CITY OF ALBUQUERQUE

November 23, 2016

Re: Animal Humane Park Phase 1
615 Wyoming Blvd SE
Traffic Circulation Layout
Architect's Stamp 11-15-16 (L19D058)

# SITE PLAN

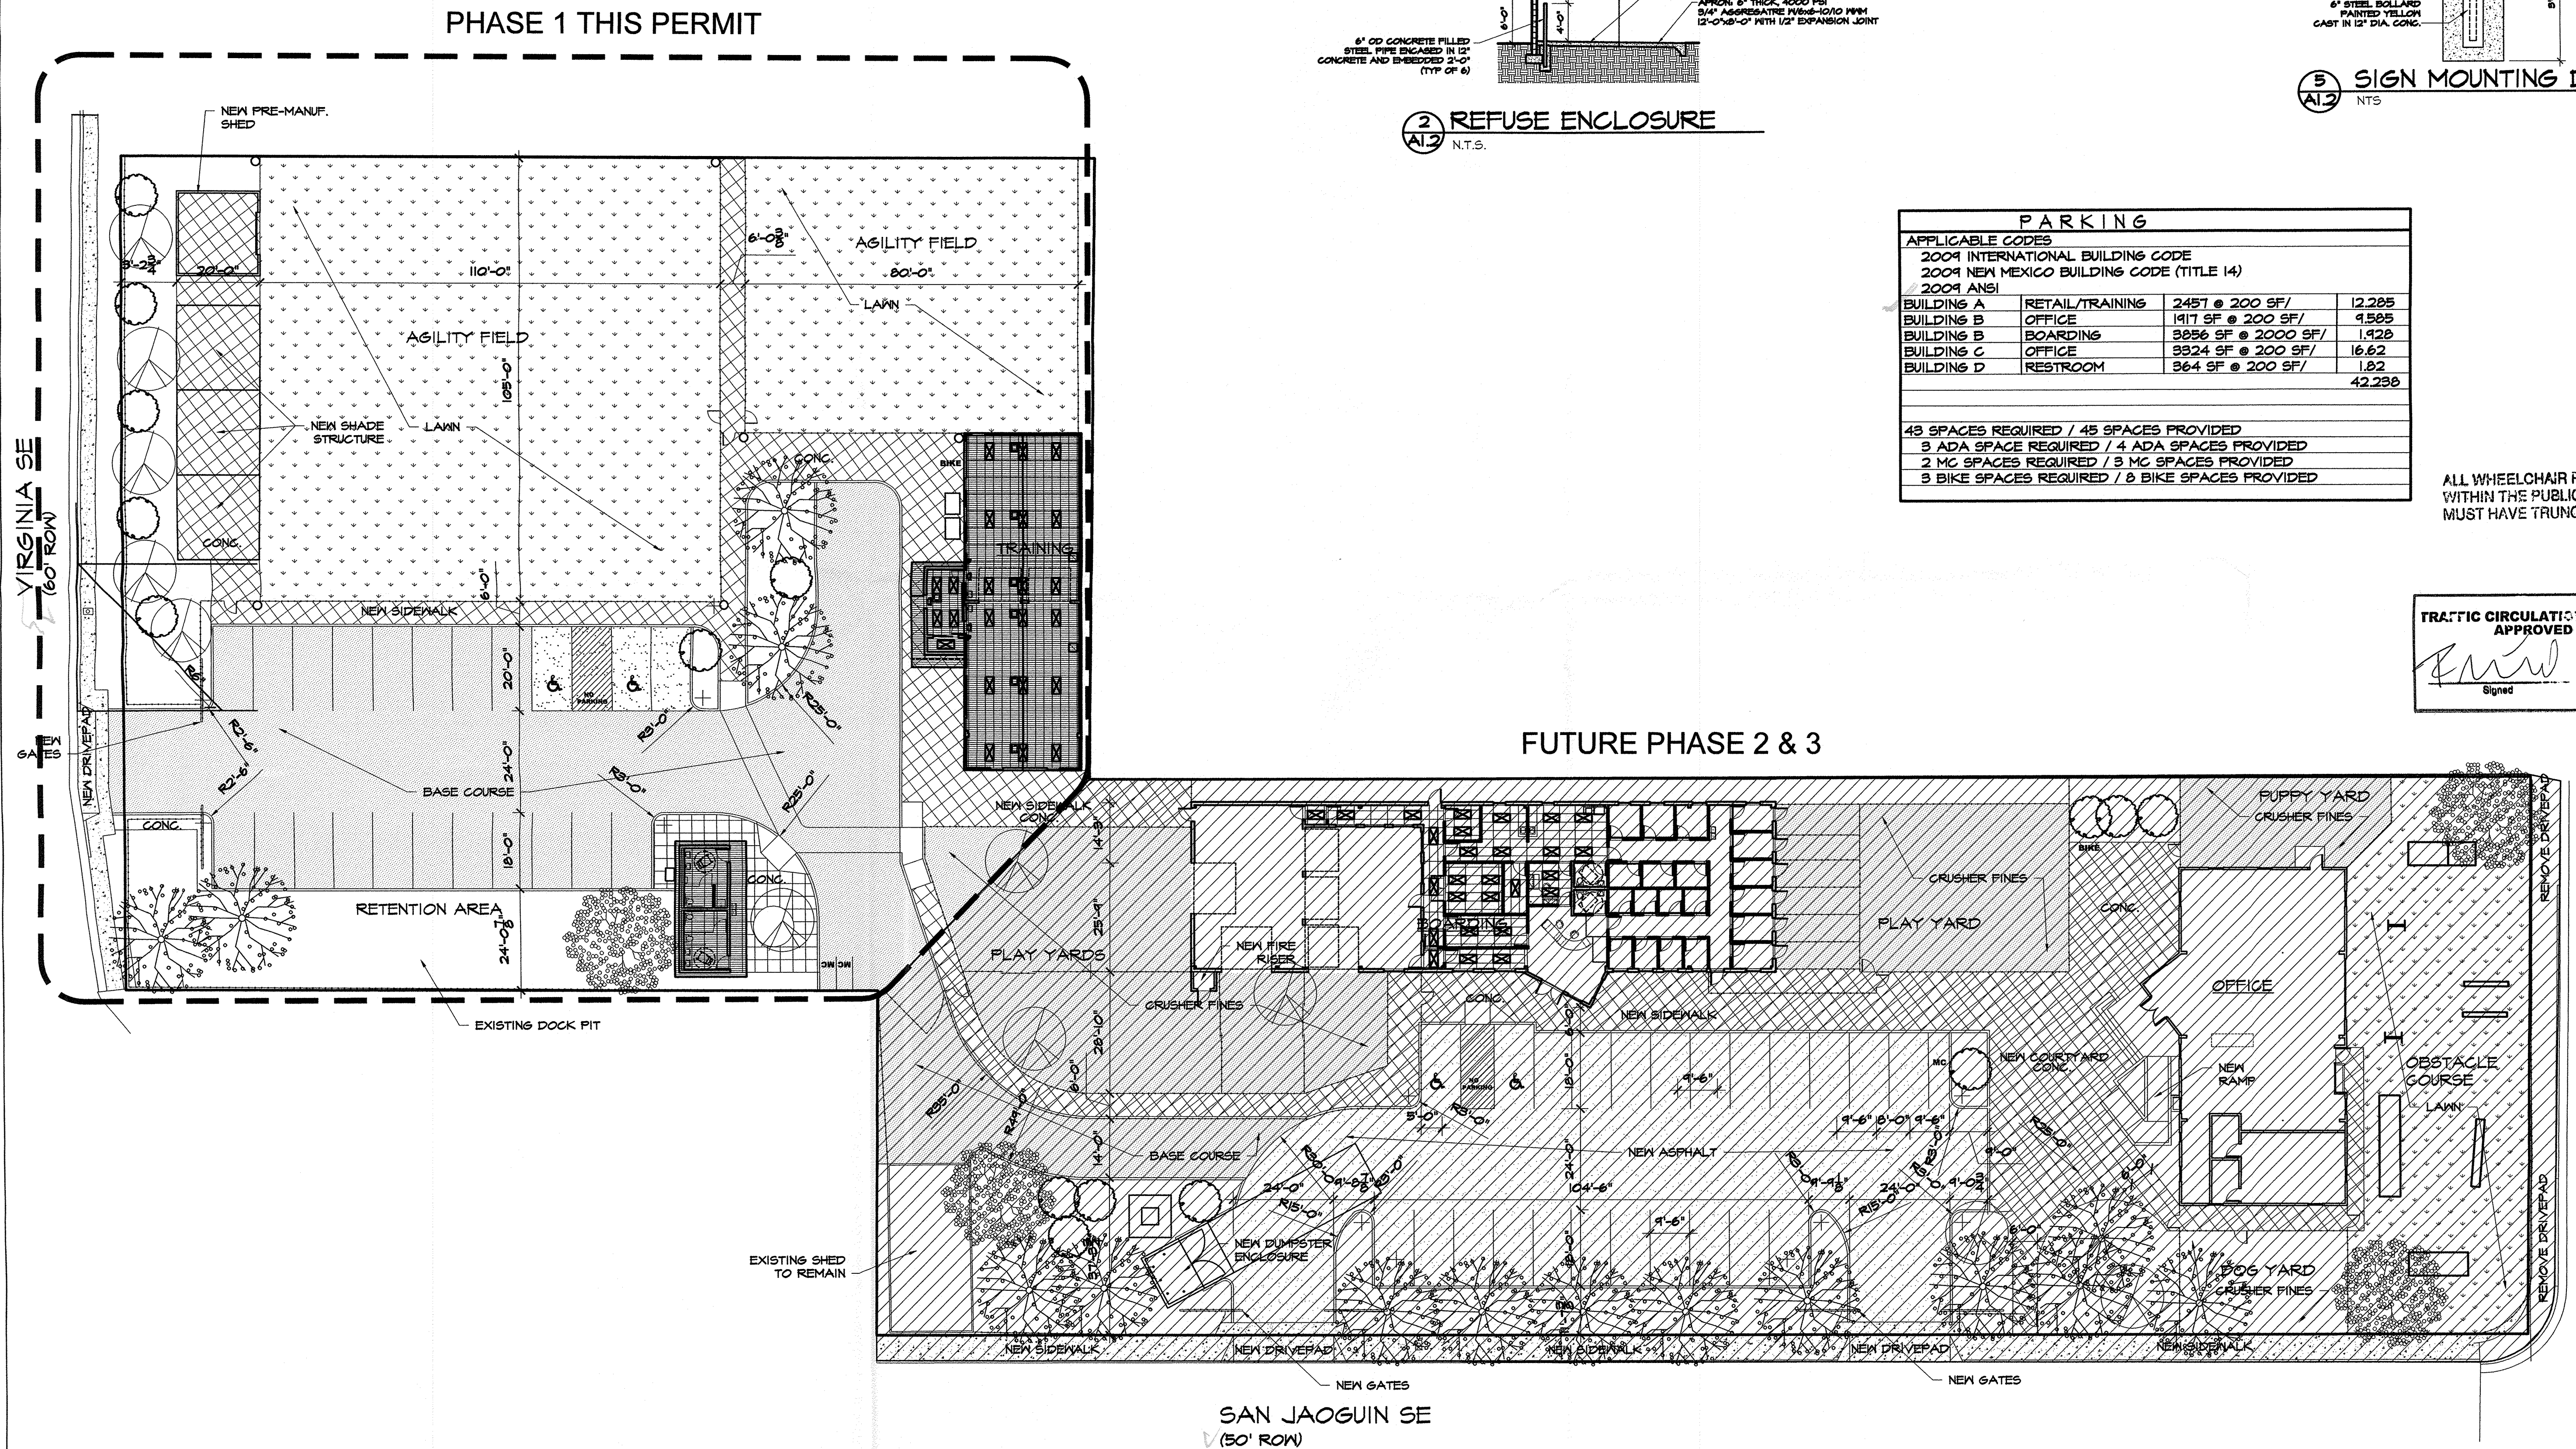
1. List the number of parking spaces required by the zoning code for each phase as well as the proposed number of parking spaces including bicycle and motorcycle parking.
2. Identify the right of way width, medians, curb cuts, and street widths on Virginia St SE.
3. Show the clear sight triangle and add the following note to the plan:
"Landscaping and signage will not interfere with clear sight requirements. Therefore, signs, walls, trees, and shrubbery between 3 and 8 feet tall (as measured from the gutter pan) will not be acceptable in the clear sight triangle.
4. Please specify the City Standard Drawing Number when applicable.
5. Please include two copies of the traffic circulation layout at the next submittal.
